New O'Connell Street Public School Parramatta (SSD 7372) – Notice of Exhibition

TAB A – Request for Further Information/Clarification

Figure 11: Set-down and pick-up locations – Marist Place and Market Street (source: RtS)

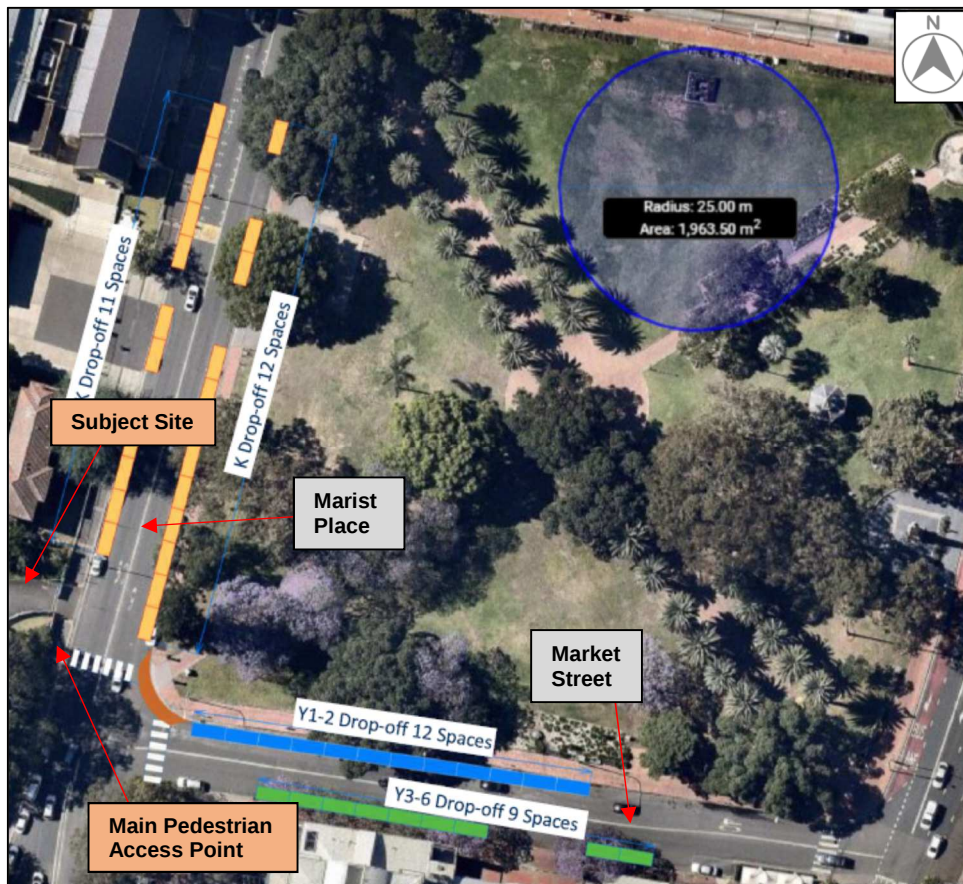
Section 3.3.2 of the TIA report recommends on-street student set-down/pick-up area including along Market Street. Market Street is a layover area for buses and is utilised by several bus routes. At present it does not have the capacity to accommodate a set-down/pick-up area. School bus services for the school also utilise Market Street as a layover.

Section 7.5 of the TIA report proposes a 'Bus Zone' is proposed to be located somewhere on Marsden Street/Marist Place to accommodate up to three buses at time. The requirement of a 'Bus Zone' is supported however, it should be located on Market Street where numerous bus services currently operate. As noted above, this would further conflict with the proposed student set-down/pick-up at Market Street.

The proposed student set-down /pick-up, parking and bus zone configuration along Market Street requires further assessment to ensure the needs of bus operation is accommodated without compromising the safety of pedestrians particularly school children. Alternative options needs to be considered as impact on existing bus operation would be detrimental. This matter should be addressed in consultation with TfNSW and Council.
